From: Jennifer Ballinger
Sent: 18 March 2018 12:41
To: Caroline Ford
Subject: Berry Hill Road, Adderbury - 17/02394/OUT

Thank you for consulting the Design and Conservation Team on the additional information in the form of a Heritage Statement for the above application.

Berry Hill Road, Adderbury - Site Plan - Rev E

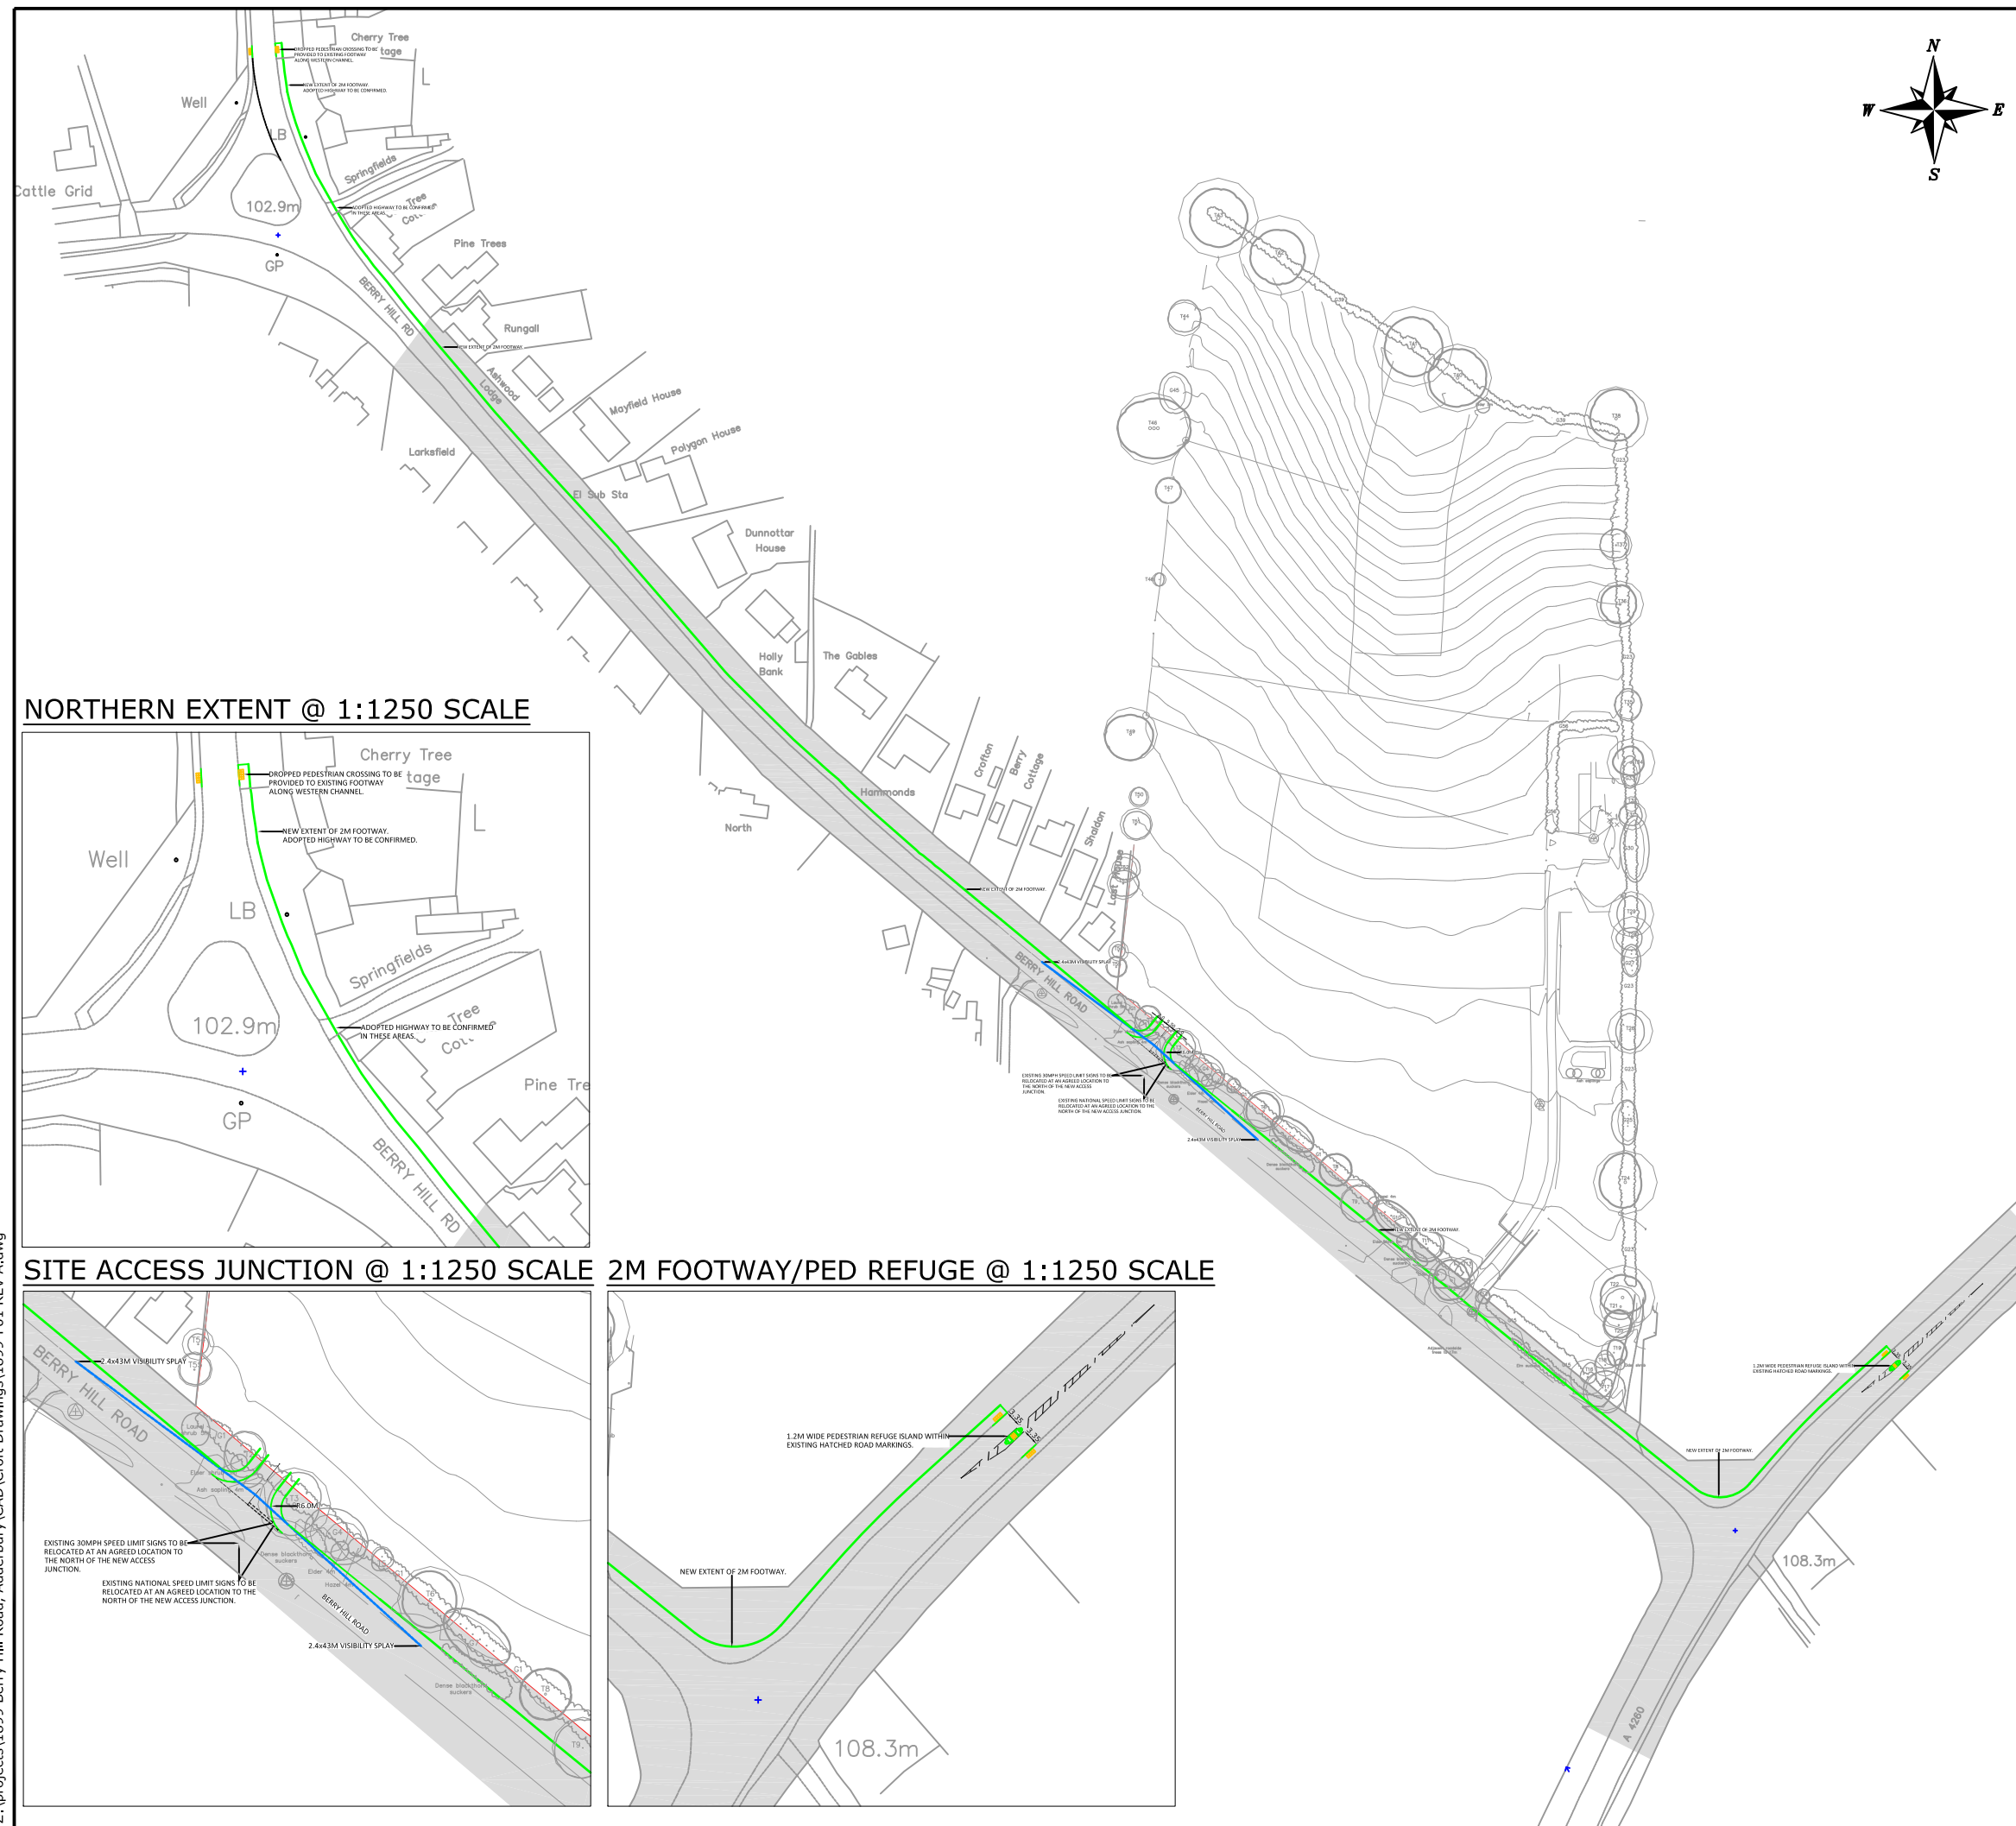
The development does indeed 'stand alone in the landscape' and is as such a non-traditional extension to the settlement. The additional information provided in the form of an indicative layout confirms this. The proposed layout is very suburban in form and does not follow any historic, traditional or local parameters.

The illustrative layout shows view lines leading through to the church, however due to the suburban nature of the layout of the site these views appear incidental rather than funnelled. There is little sense of the significance of the church that is usually seen in more traditional and historical settlement layouts.
